# CITY OF ALBUQUERQUE

**RE: Carlisle Marketplace  
2100 Carlisle NE  
Conceptual Grading Plan Stamp Date: 12/3/19  
Drainage Report Stamp Date: 12/3/19  
Hydrology File: H17D097**

Based on the submittal received on 12/3/19, the Conceptual Grading Plan and Drainage Report are approved for Site Plan for Building Permit.

| REVISION                                                                                               |                      |         |           |
|--------------------------------------------------------------------------------------------------------|----------------------|---------|-----------|
| SHEET NUMBER:                                                                                          | C-100                |         |           |

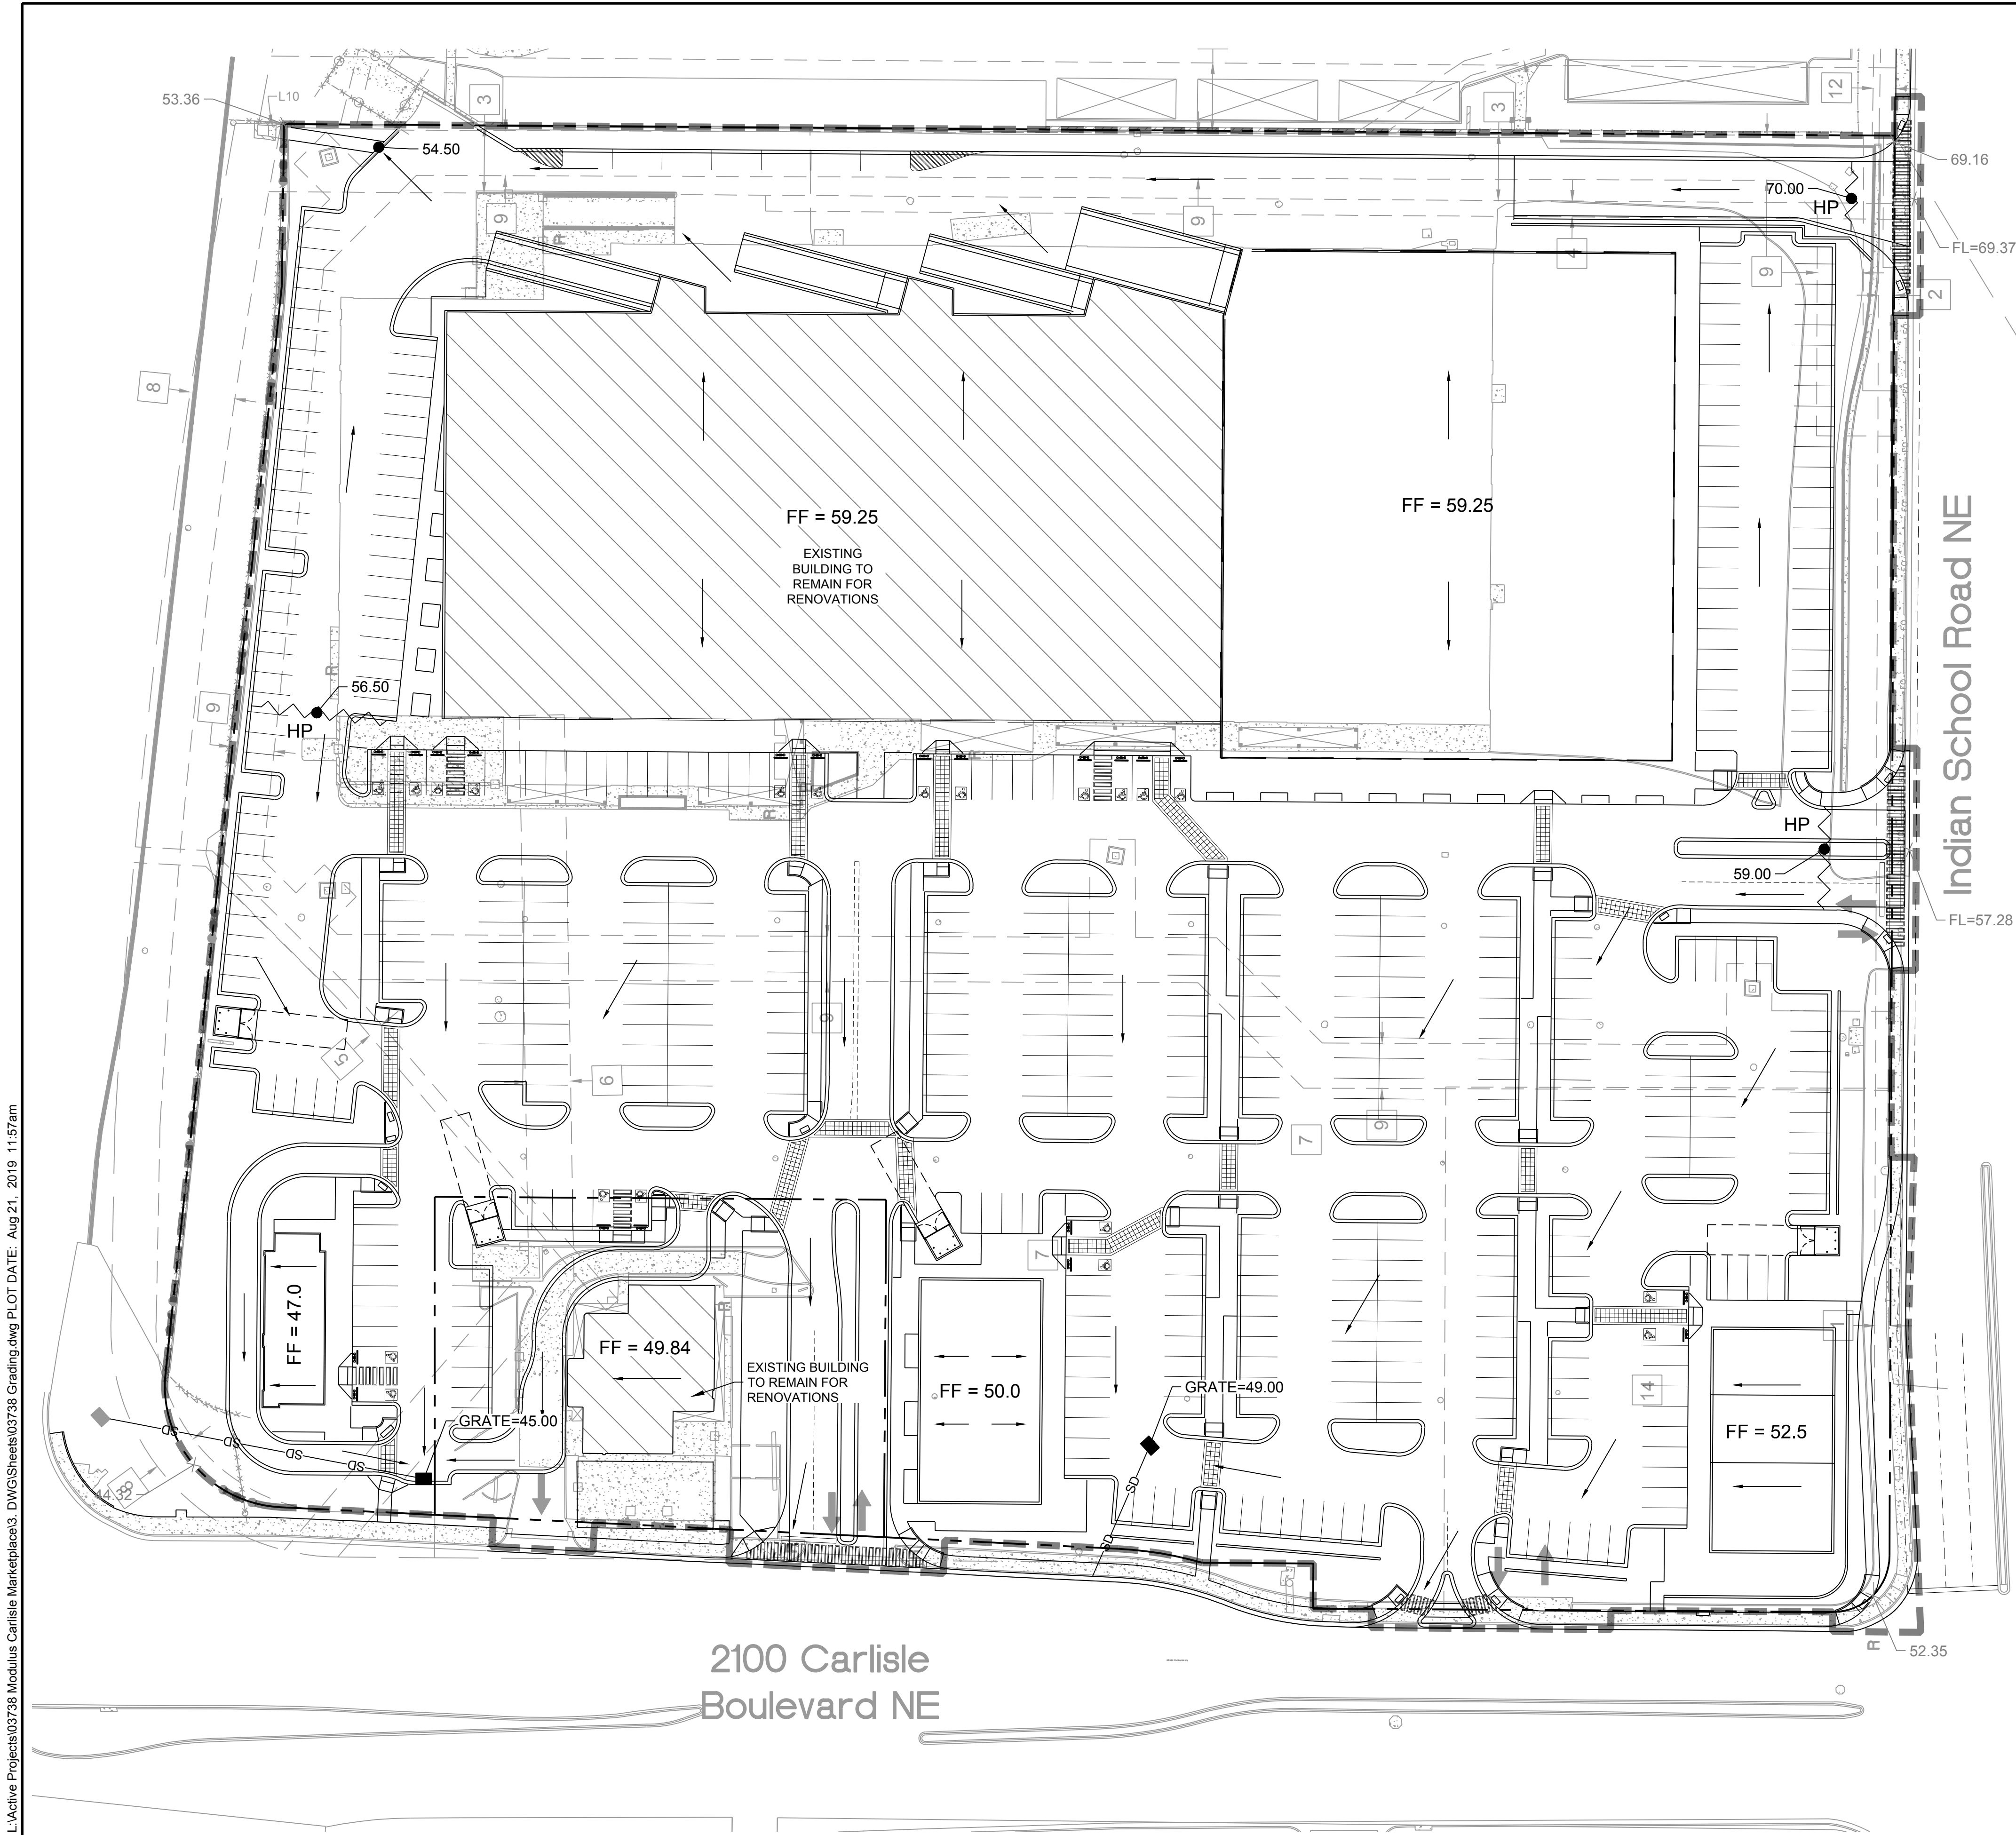
1. The storm drain (inlets manholes, pipes, inverts, etc...) in Carlisle and I-40 frontage needs to be surveyed and shown on the grading plan.
2. Required SWQV needs to be calculated for the impervious area only and using the redevelopment amount (0.26/12"). It looks like you multiplied .34/12" by the impervious area.

4. Payment in Lieu of onsite management of the SWQV must be made prior to Building Permit (Amount T.B.D).
5. Please show and label the pond(s) and include a label on each with the SWQV and elevation, the 100-year volume and elevation, the peak 100 year inflow and outflow, the spillway crest elevation, and the spillway flow depth.

#### KEYED NOTES

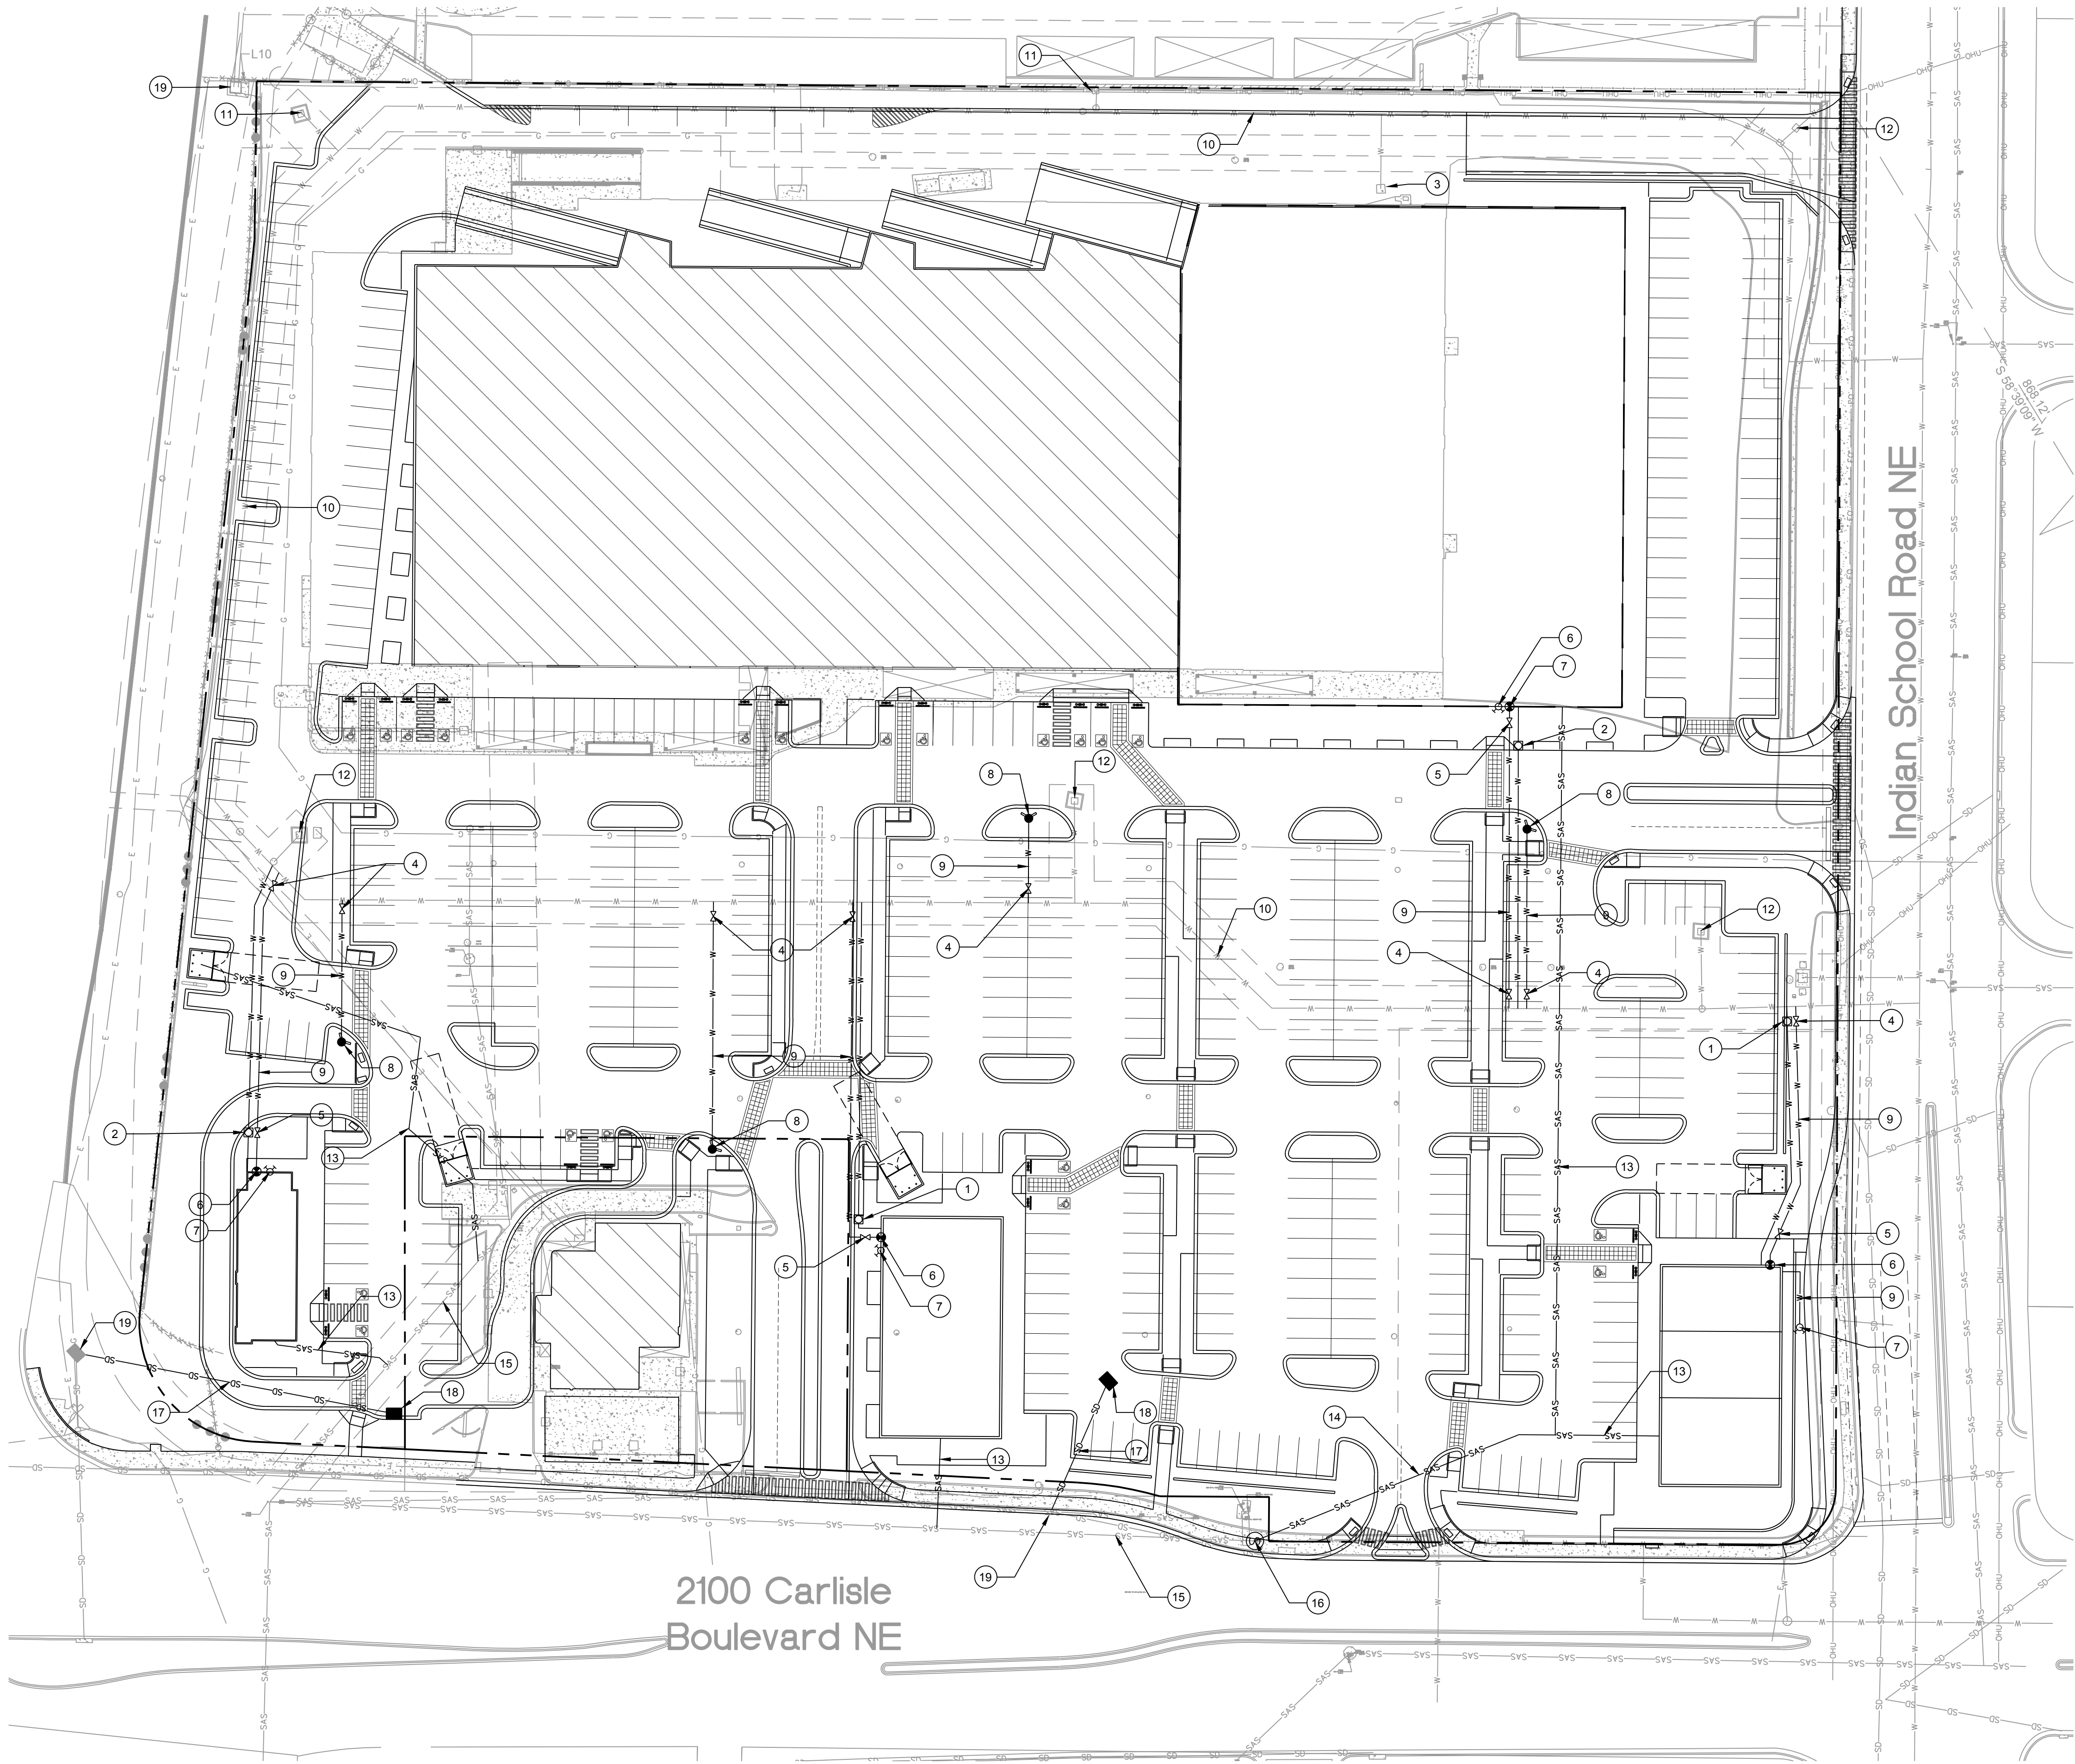
Additionally, keyed note 19 on sheet C-300 proposes a storm drain pipe at the existing inlet/rundown at the northeast corner of the property.

If this approach is agreeable to you, I will update the drainage report accordingly. Please let me know and I will send you a revised report. And in regards to keyed note #19, that is an error. I will fix that and resend as well.
